Subject: RE: Planning Consultation on: AL/129/21/OUT

Engineers Comments Regarding Surface Water Drainage

Application No: AL/129/21/OUT
Registered: 10th November 2021
Site Address: Land adjacent to Woodgate Nurseries Lidsey Road Aldingbourne PO20 3SU
Grid Reference: 493703 103888
Description of Works: Outline planning application with all matters reserved (except access) for residential development with up to 95 No dwellings (Use Class C3), informal and formal public open space, landscaping, drainage and other associated works. This application is a Departure from the Development Plan.

SURFACE WATER DRAINAGE STRATEGY (see Appendix 6)

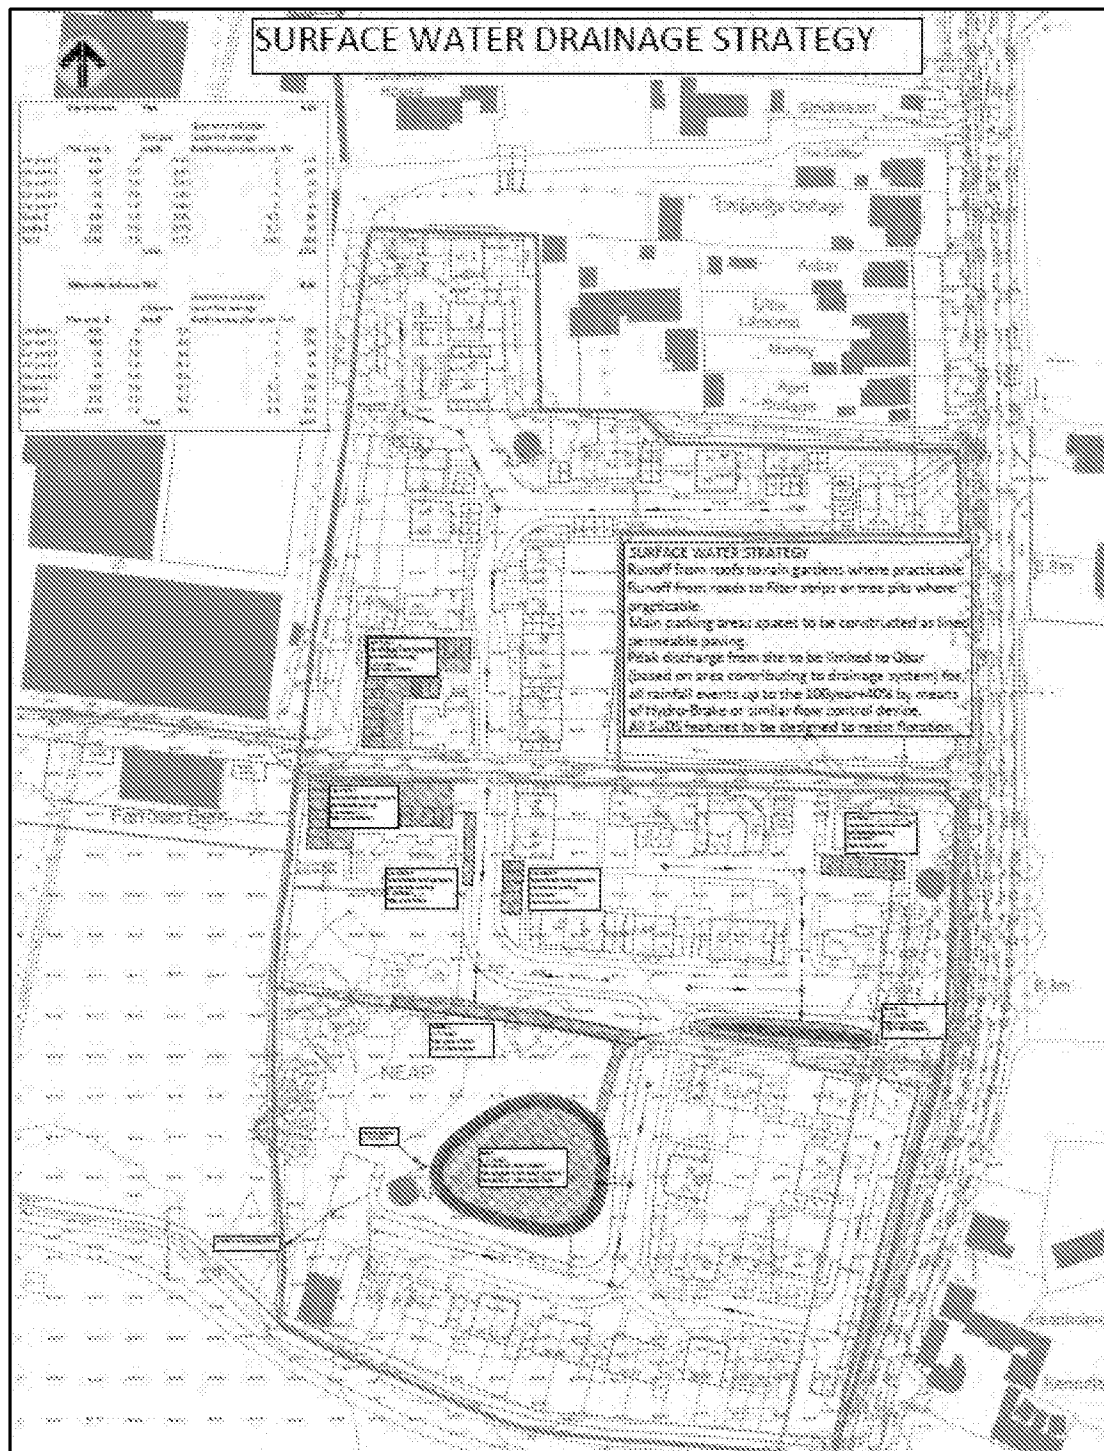
1. We will require an impermeable area plan so that the QBAR calculations can be accurately checked – 3.5l/s seems reasonable but has not been scrutinised.
2. One of the swales appears to conflict with a tree root protection area, this will need to be relocated.

SURFACE WATER STRATEGY

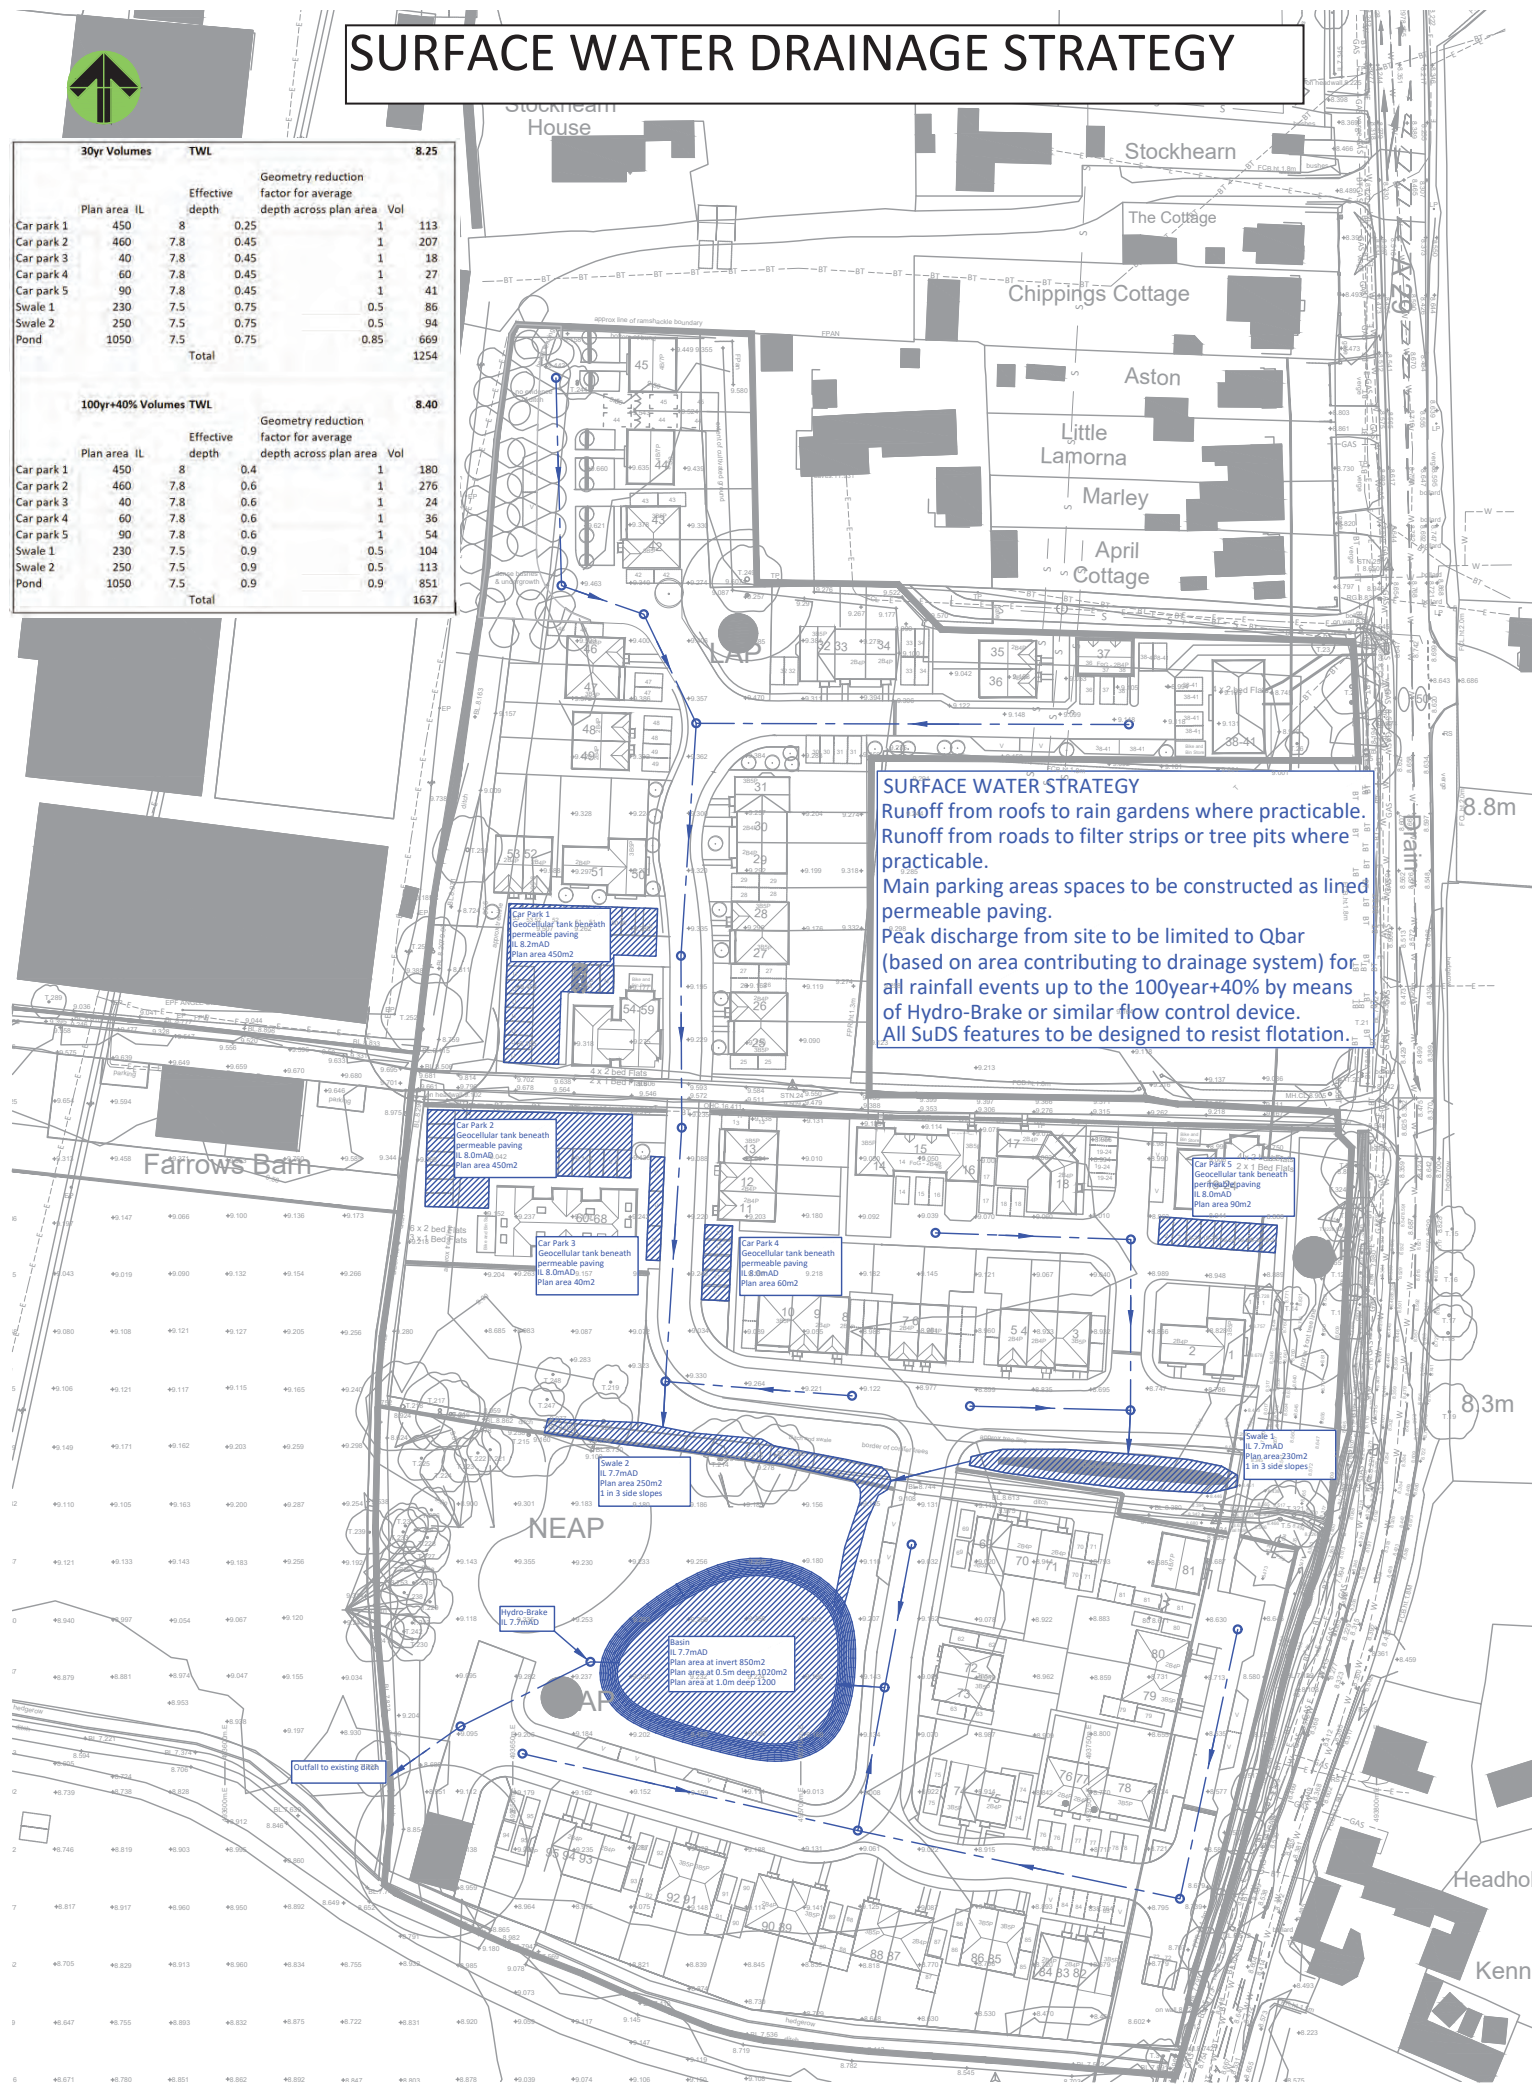
4. Calculations will need to be submitted to show that the effects of buoyancy have been counteracted. For this purpose groundwater must be assumed to be at ground level as there was not a groundwater monitoring point in the vicinity of the proposed basin.

5. Calculations will be requested to show that the design accounts for a surcharged outfall. These will need to show surcharge equivalent to the top of the receiving watercourse bank.

7. The drainage layout will require further detail, this is covered within Note 10 of the Drainage Checklist included within the FRA appendices. Please contact me if this is unclear.
